# Rezoning Transportation Analysis

Petition Number: 2022-219

## Revision Log:

Date	Description
4-26-23	First Review (IW)
6-21-23	Second Review (DR)

RZ-1.0

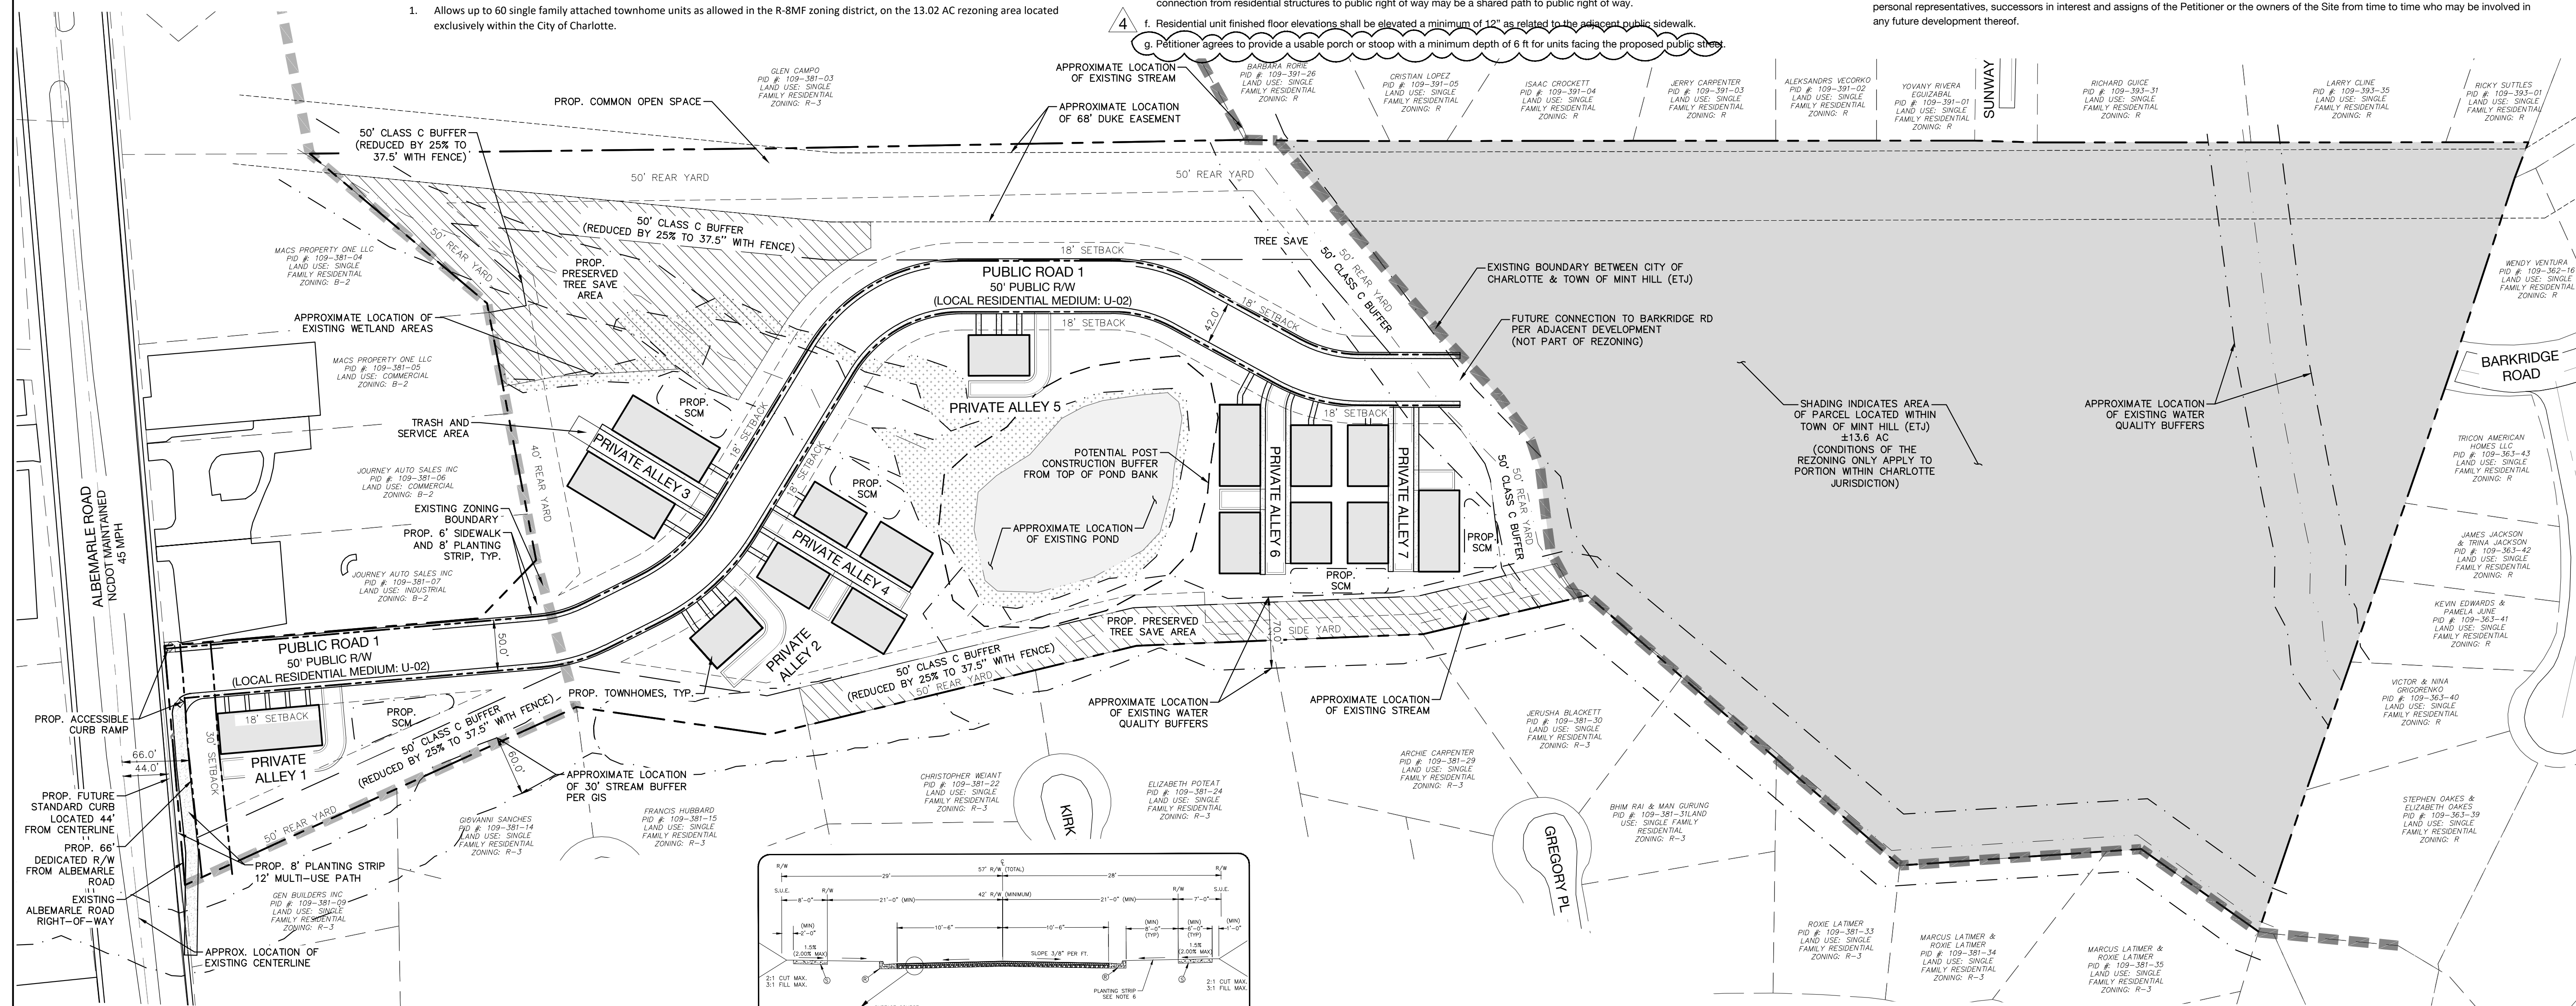
- 3. Revise site plan and conditional note(s) to commit to dedicate 66' right-of-way from the road centerline or 64' with a 2' SUE. The site plan shall label and dimension the right-of-way from the road centerline.

**Clarifying comment from 6.21.2023:** Add conditional note to dedicate 66' right-of-way from the road centerline.

8. CDOT requests petitioner revise site plan and conditional note(s) to commit to constructing a right turn lane on Albemarle Road per coordination with NCDOT due to volume and speed in this area of the city.

**Clarifying comment from 6.21.2023:** In coordination with NCDOT, label and add a conditional note to constructing a right turn lane on Albemarle Road.

9. CDOT requests petitioner revise site plan and conditional note(s) to commit to building Public Road 1 to the Local Residential Wide Street Section (CLDSM U-03A).

**Clarifying comment from 6.21.2023:** Revise site plan and conditional to commit to constructing Public Road 1 to a Local Residential Wide Street Section (CLDSM U-03A).

10. Add a conditional note specifying “the Petitioner shall dedicate and convey in fee simple all rights-of-way to the City before the site’s first building certificate of occupancy is issued. CDOT requests rights-of-way set at 2’ behind back of sidewalk where feasible.”  
Update conditional note 5 under “Transportation” to have SUE 2’ behind MUP instead of 1’ as shown. 2’ is necessary for the maintenance of the path.

**Clarifying comment from 6.21.2023:** Revise conditional note with SUE to have 2’ instead of 1’ as shown in conditional note 7. 2’ is necessary for the maintenance of the path.

13. Revise site plan and conditional note(s) to better illustrate what conditional note 3 under “Transportation” is referencing. It states ADA ramps will be provided at the corner of Public Road 1 and Albemarle Road as illustrated but there is not illustration of this proposed improvement.

**Clarifying comment from 6.21.2023:** Clearly show and label accessible curb ramps at the corner of Public Road 1 and Albemarle Road.
